## **Planning Act 2008 (as amended) – Section 51**

### **Application by Total Energies and Corio Generation for an Order Granting Development Consent for the Outer Dowsing Offshore Wind (Generating Station) (EN010130)**

#### **Advice following issue of decision to accept the application for examination**

This document may only be used for the purpose for which it was commissioned and in accordance with the terms of engagement for that commission.
Unauthorised use of this document in any form whatsoever is prohibited.

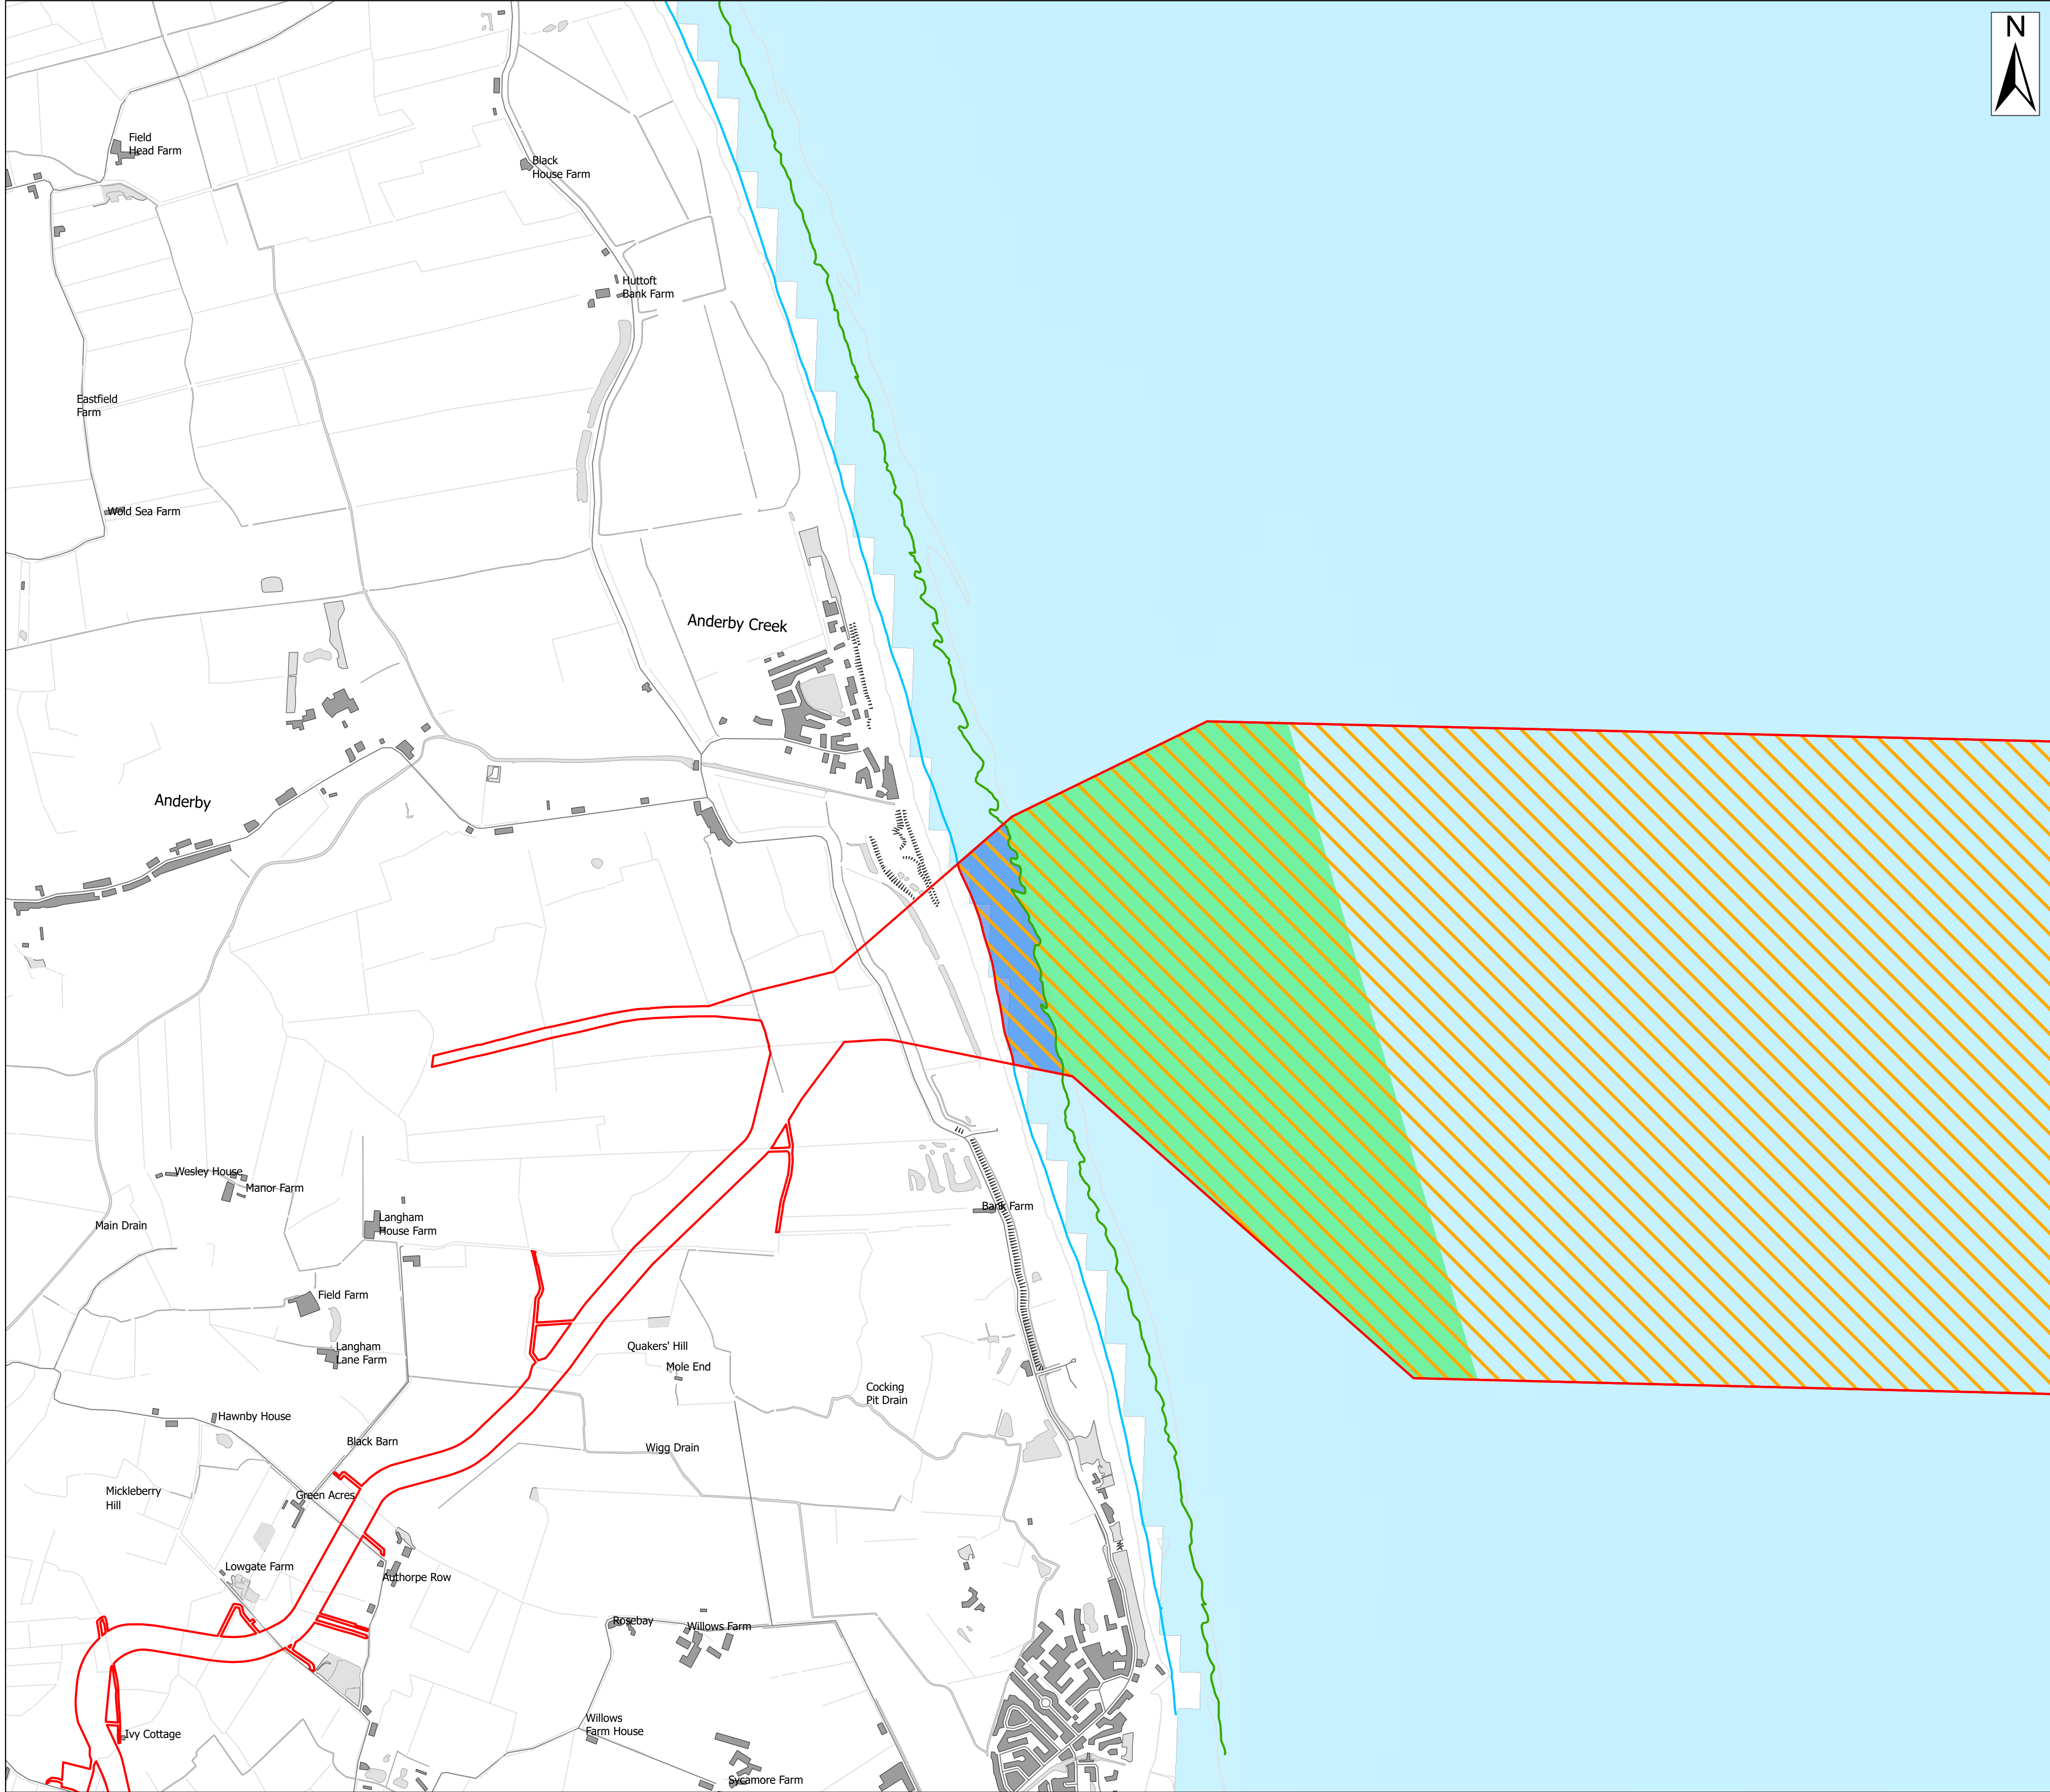
- **Onshore Works Plans** (Doc 2.1)
  - Ensure consistency between colours used in the Legend e.g., yellow colour is bright on legend but appears dull on plan.
- **Offshore Works Plans** (Doc 2.2)
  - Ensure consistency between colours used in the Legend e.g., green colour is bright on legend but appears dull on plan.

- Legend of works does not fully match dDCO works as described, for example the legend description for works no 7 mentions HVAC however the work as described in dDCO does not mention HVAC.

- Labelling of identifiers used are obscured or not easily identifiable, for example Inner Dowsing Race Bank and North Ridge Special Area of Conservation (SAC) are not shown on the plan.
